April 17, 1998

RE: ENGINEER CERTIFICATION FOR NATIONS BANK @ 725 SIXTH ST. N.W.
(J-14/D62) CERTIFICATION STATEMENT DATED 4/3/98.

RE: DRAINAGE PLAN FOR NATIONS BANK SITE MODIFICATION @ 725 SIXTH ST.
N.W. (J14-D62) ENGINEER'S STAMP DATED 7/18/97

SHEET NO.
C-2

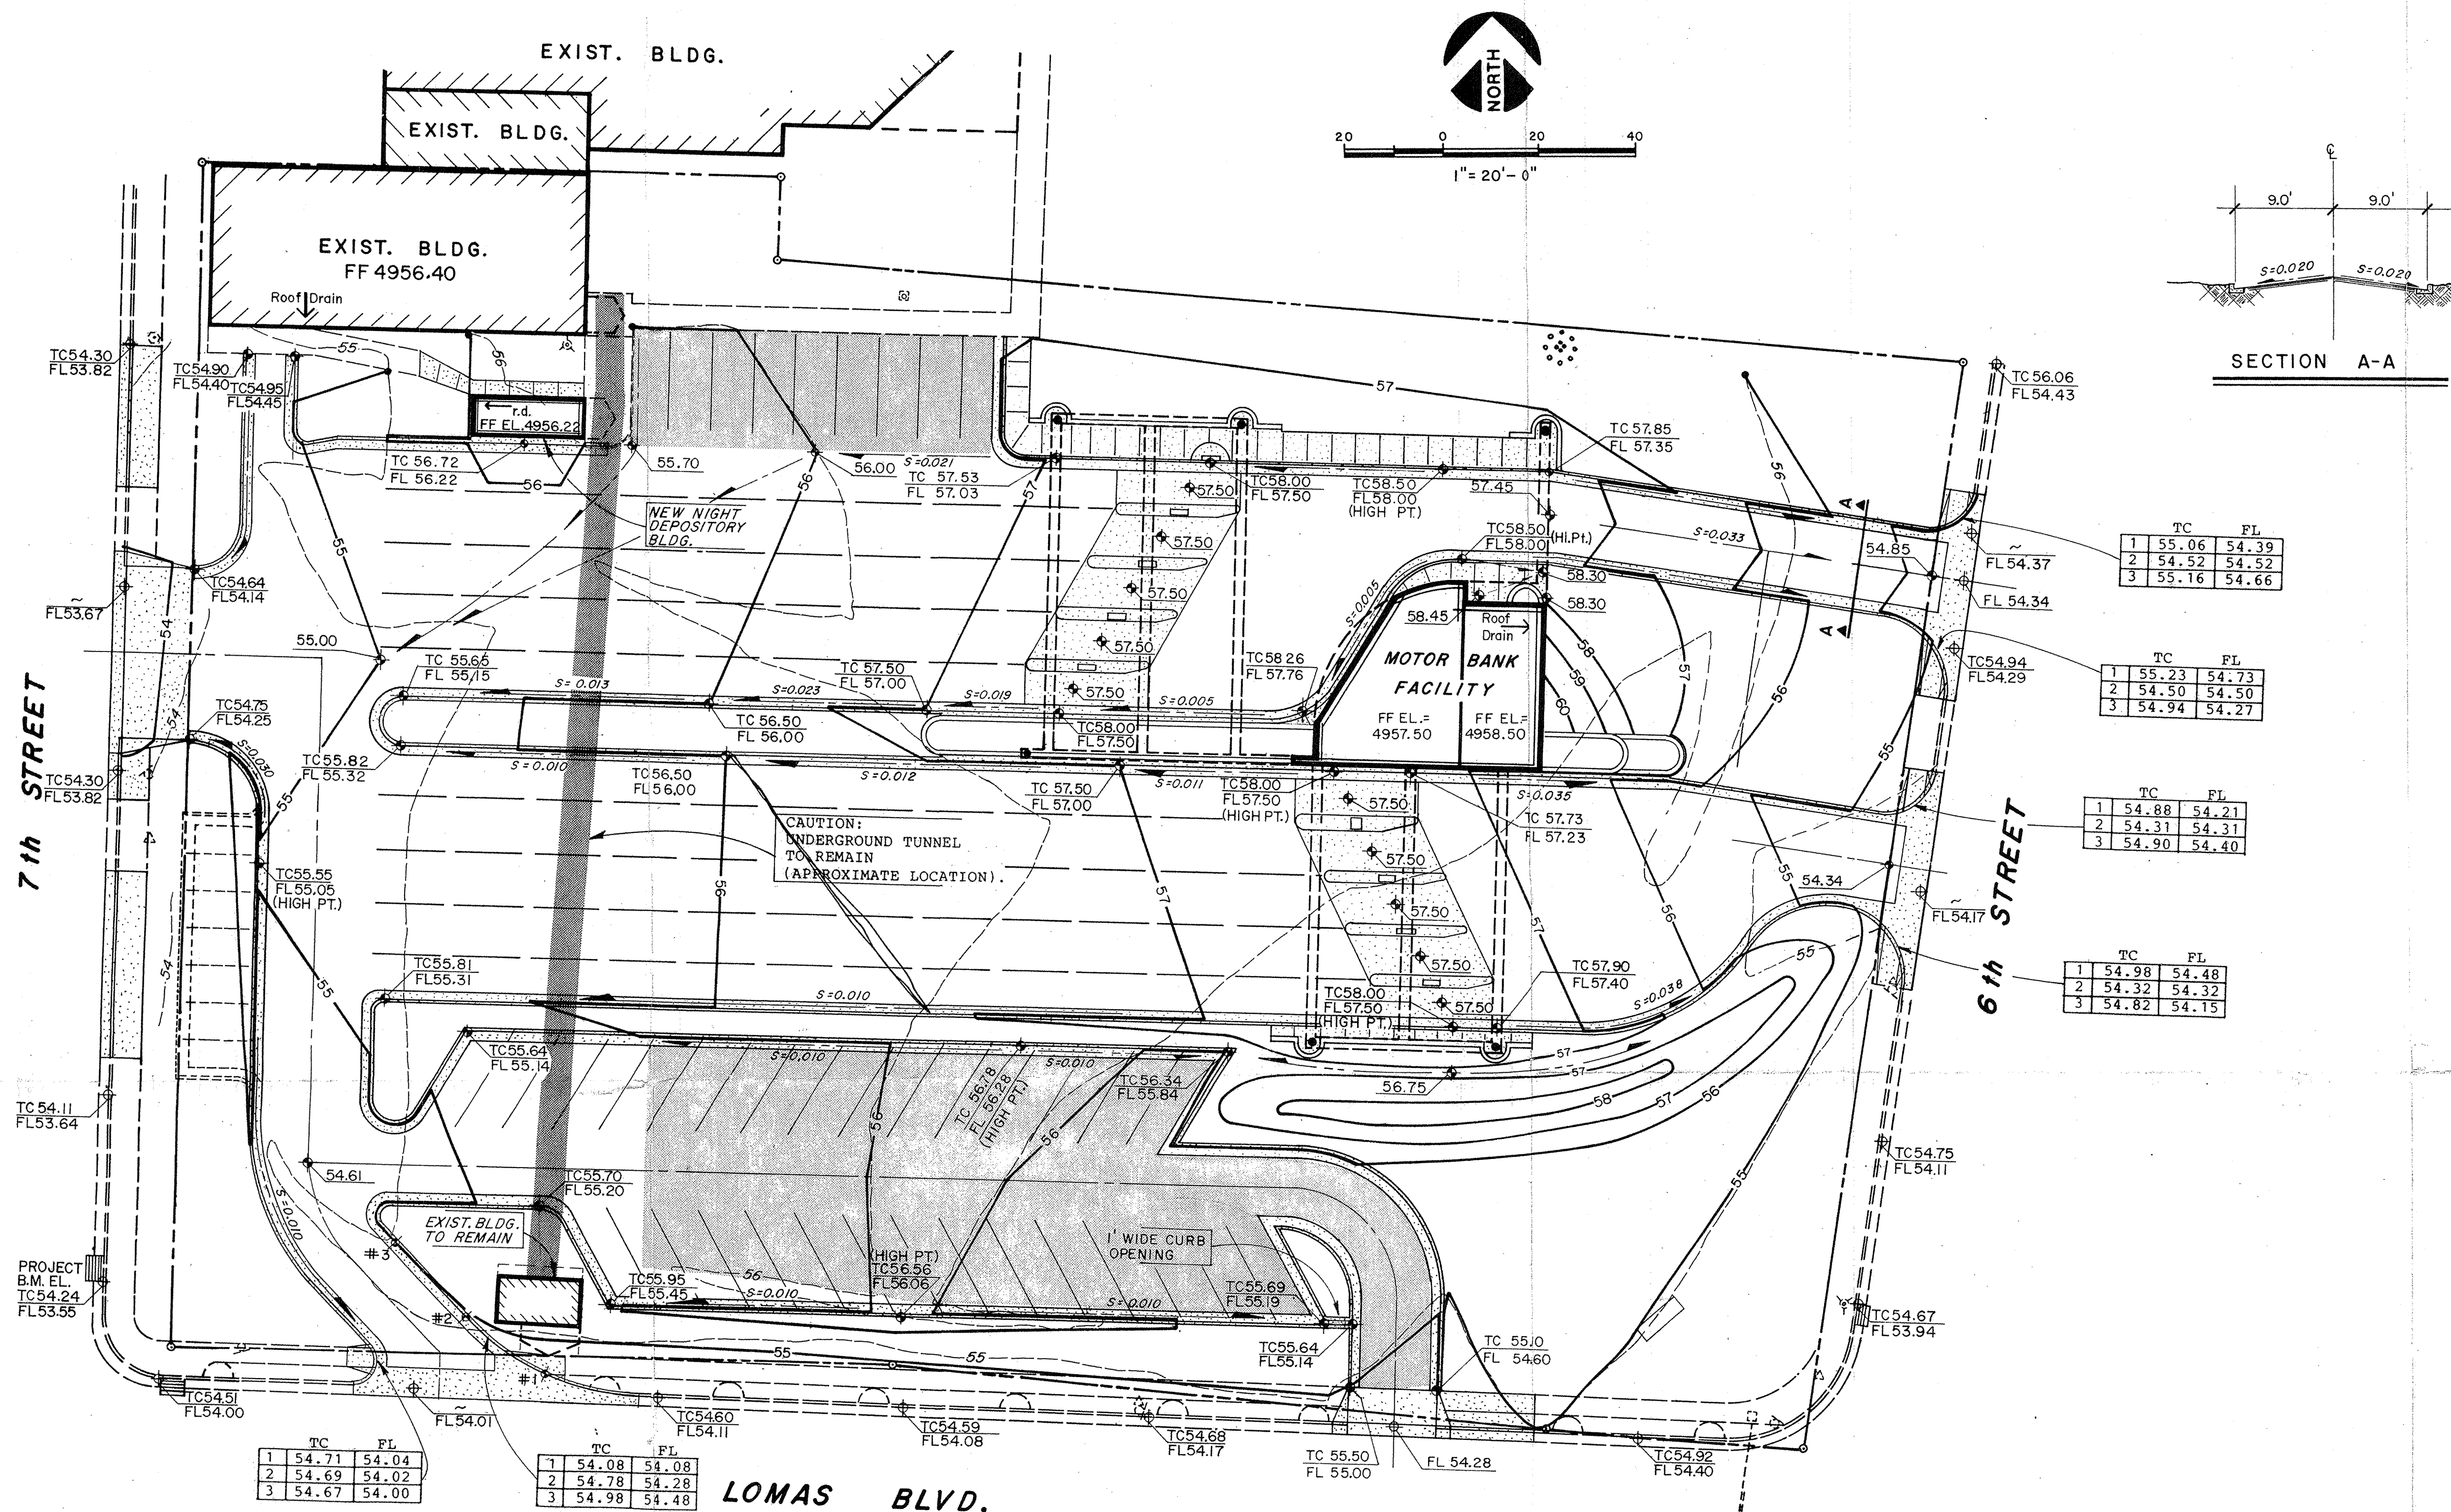
1. You will need to identify to the contractor what type of erosion control will be appropriate.

1. Note #6 on the plan states that the "Contractor is responsible for erosion control during the construction phase, including any provisions that need to be taken to divert any sediment from entering the city right-of-way". A specific type of erosion control was not stated because the site is already developed, the slopes are relatively mild and there may be no need for erosion control.
